CITY OF ALBUQUERQUE

July 29, 2025

RE: High Mesa Trail Phase 2
99999 Arroyo Vista Blvd NW
Grading & Drainage Plan
Engineer's Stamp Date: no stamp / date
Hydrology File: J07D002
Case # HYDR-2025-00265

BERNALILLO COUNTY PUBLIC WORKS DIVISION TECHNICAL SERVICES DEPARTMENT	
HIGH MESA TRAIL PHASE 2 SUBDIVISION OVERALL GRADING PLAN			
DESIGN REVIEW COMMITTEE	CITY ENGINEER APPROVAL	LAST DESIGN UPDATE	MO./DAY/YR.
CITY PROJECT NO.		ZONE MAP NO. XXXXX	SHEET 1 OF 13

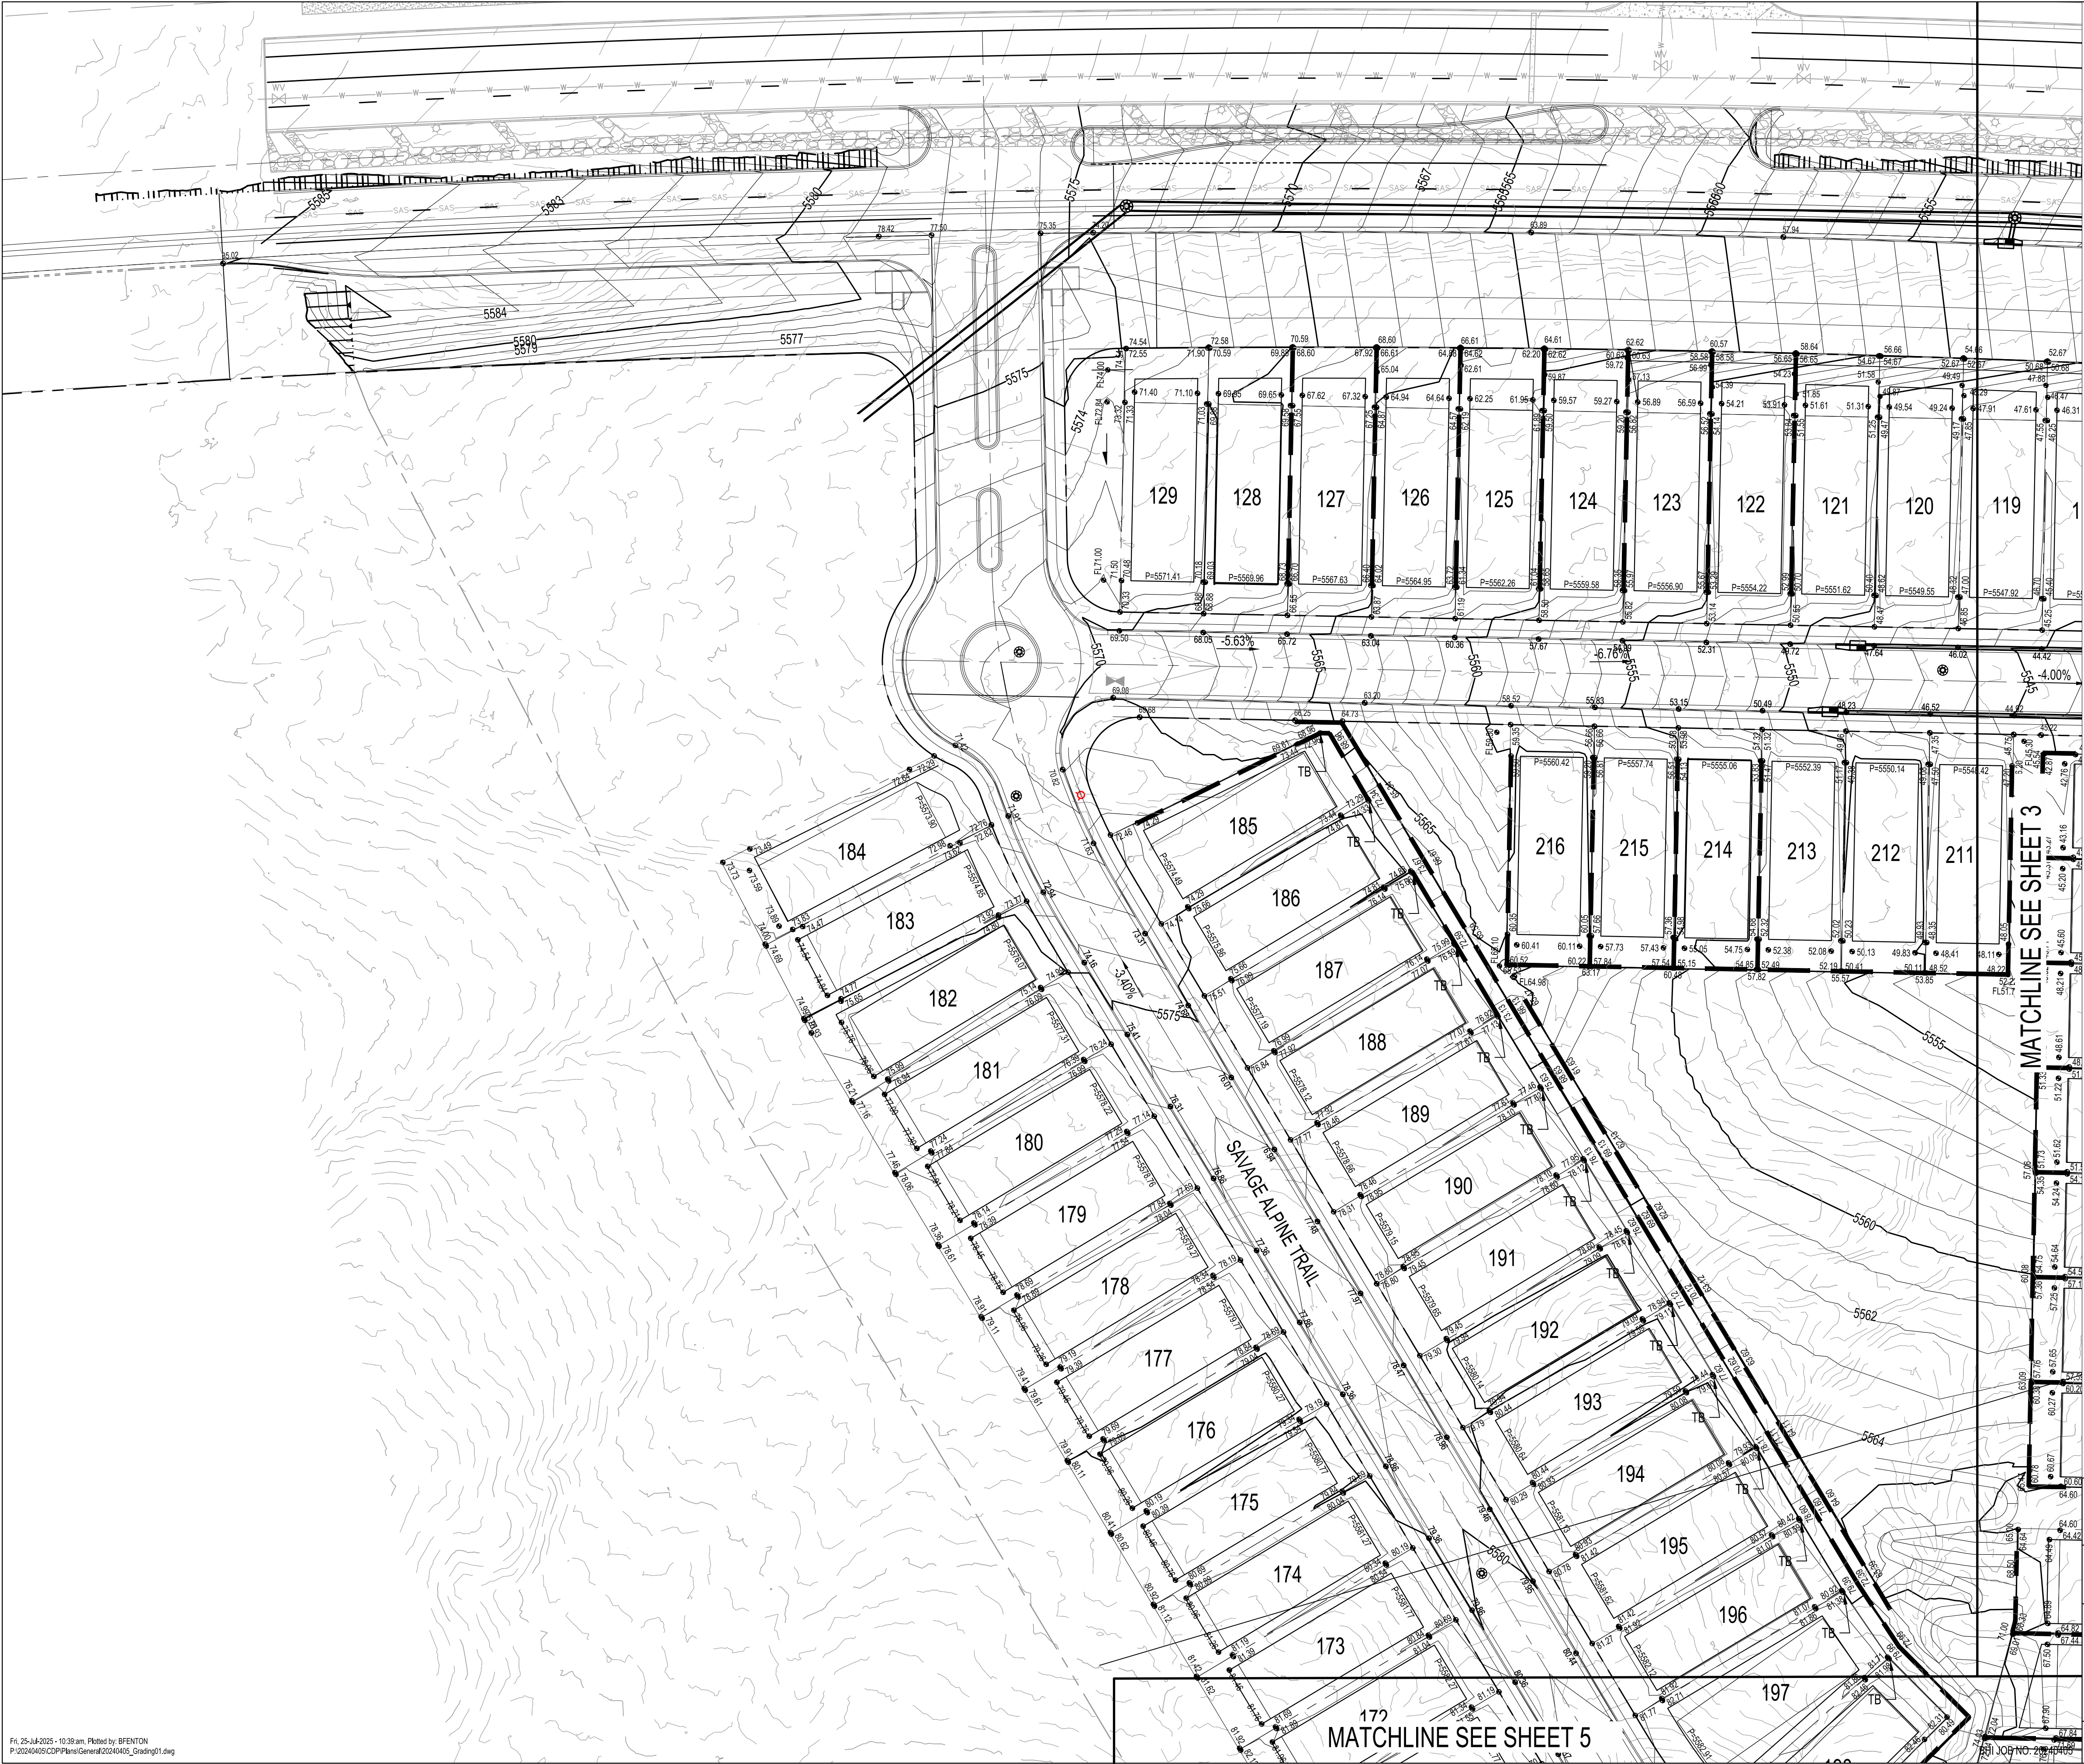
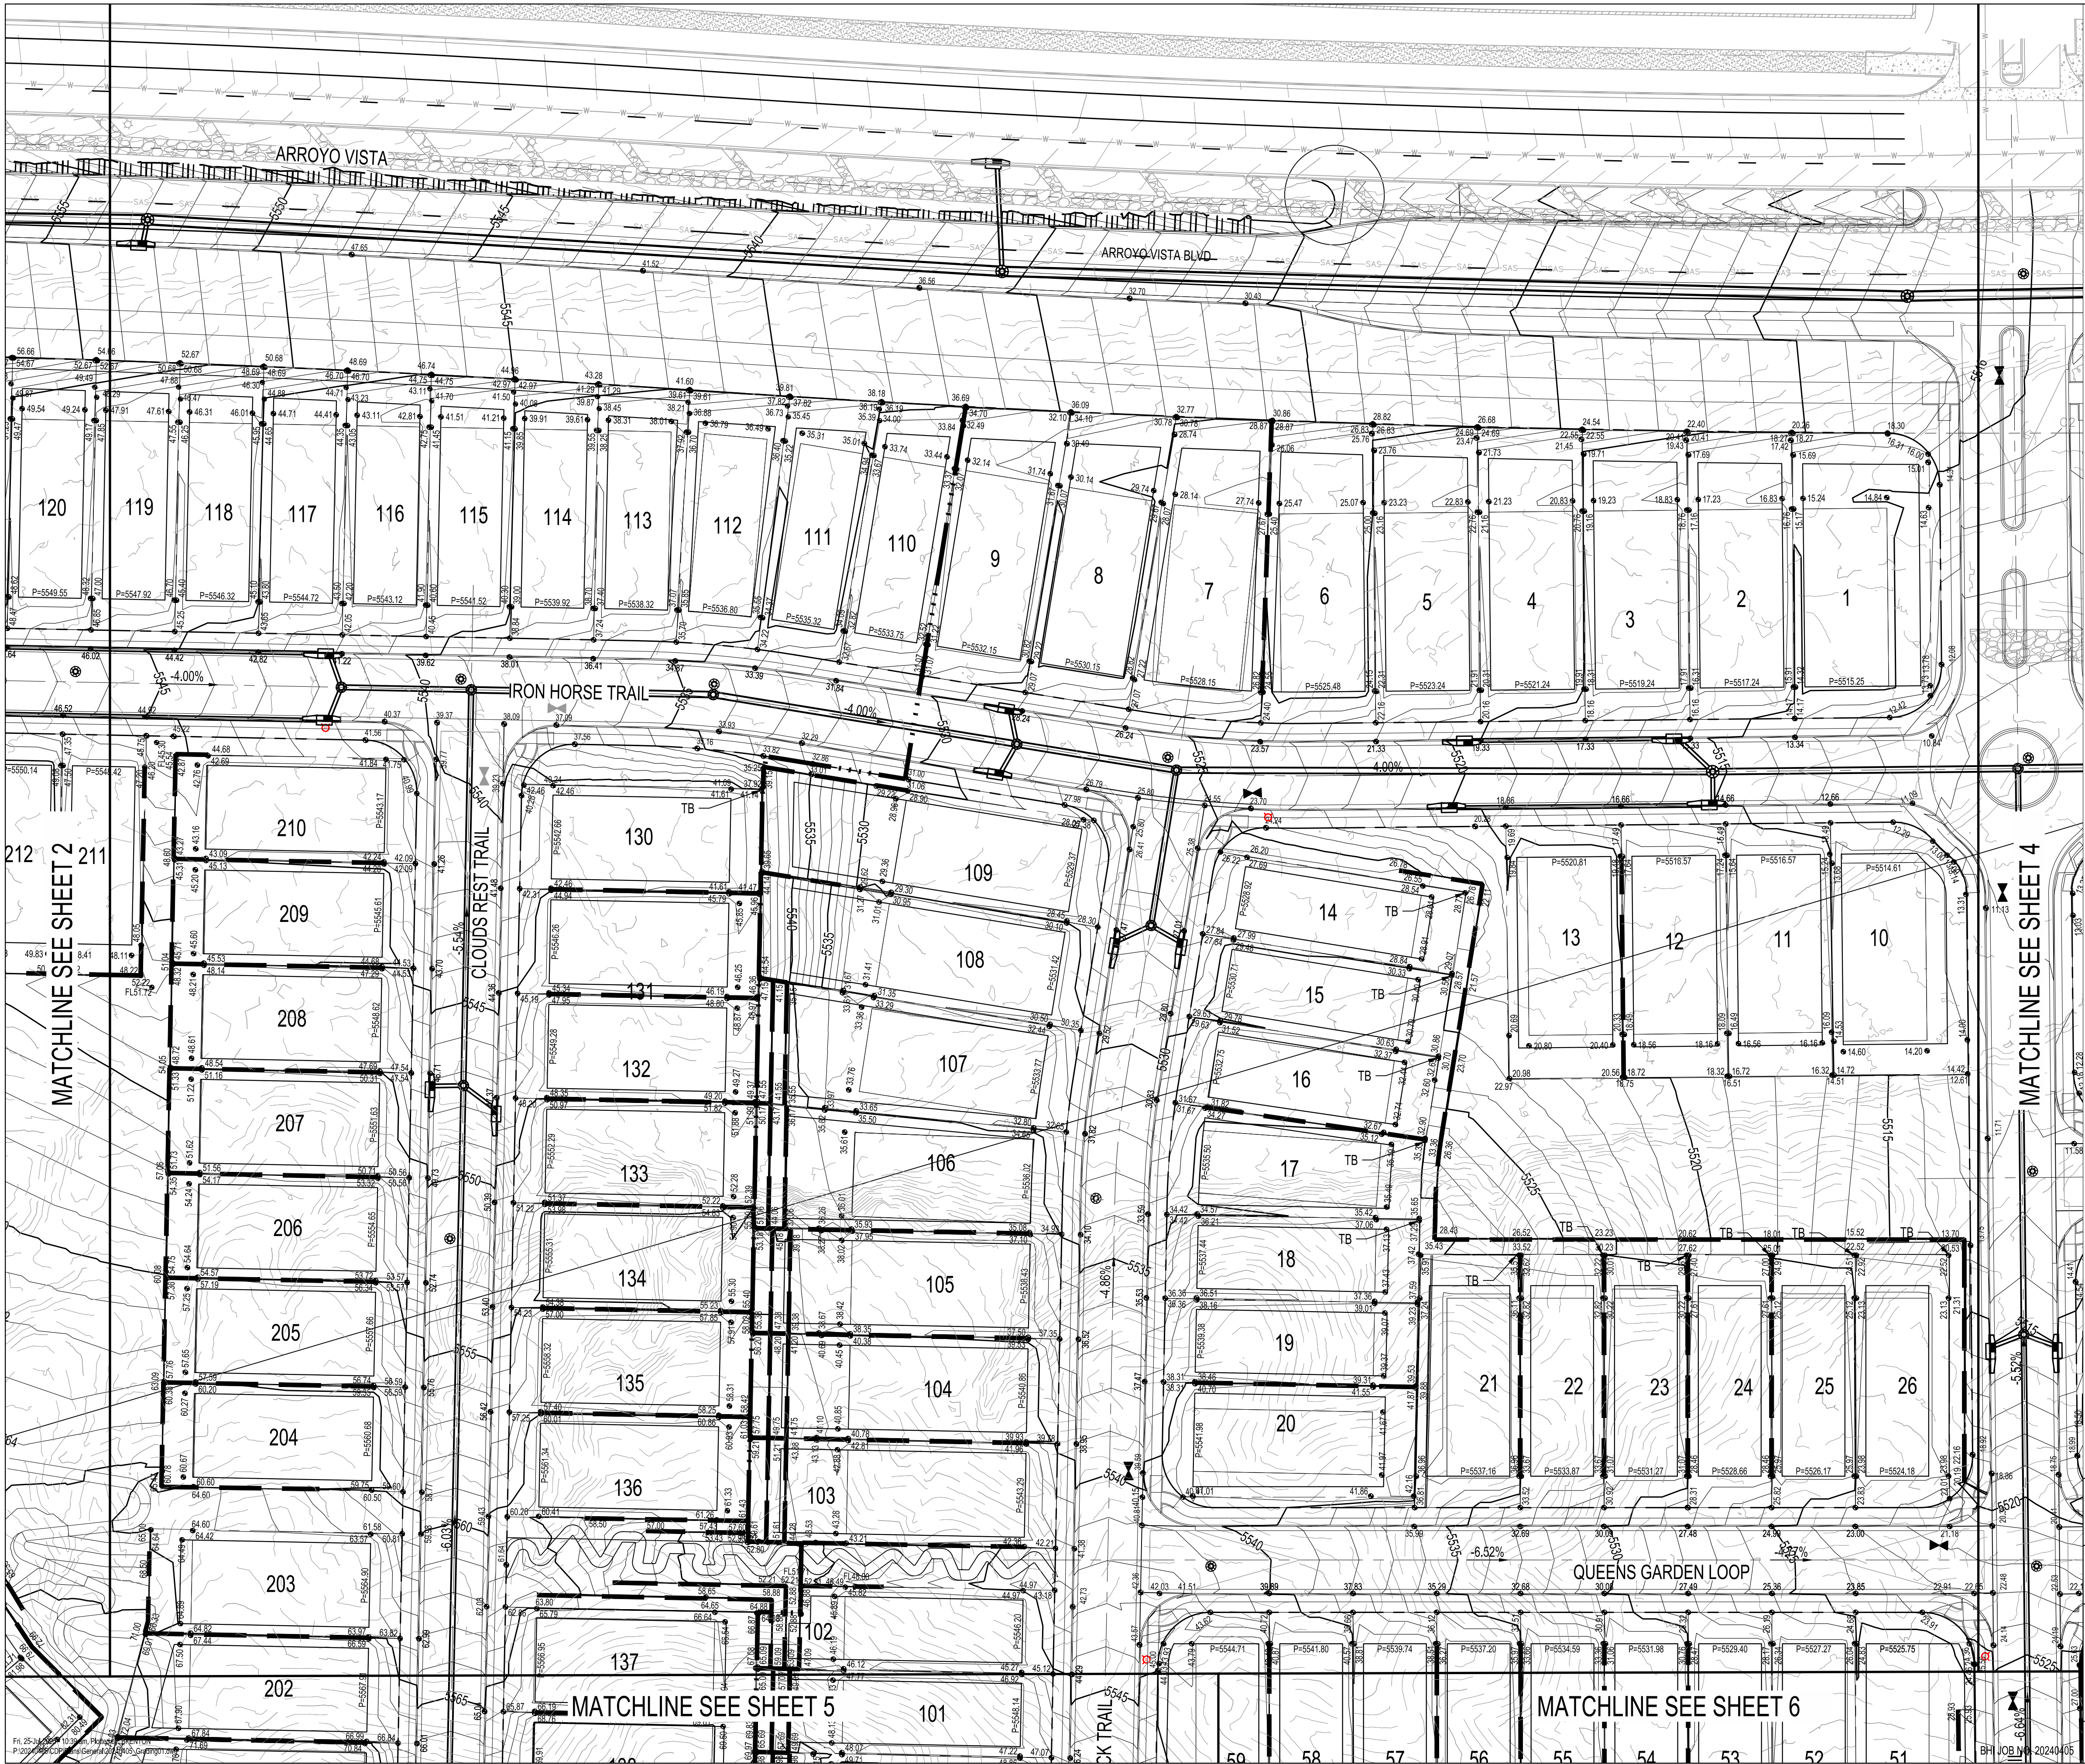
1. Per the IDO, the property owner of the property is responsible for building the adjacent half of Arroyo Vista Blvd. NW to include curb & gutter, and sidewalk. The project will have to go to the Development Facilitation Team (DFT) for approval of the Infrastructure List.
2. If only seeking approval of the Infrastructure List at this time, label the grading plan "Conceptual, Not For Construction" or similar and address all comments.
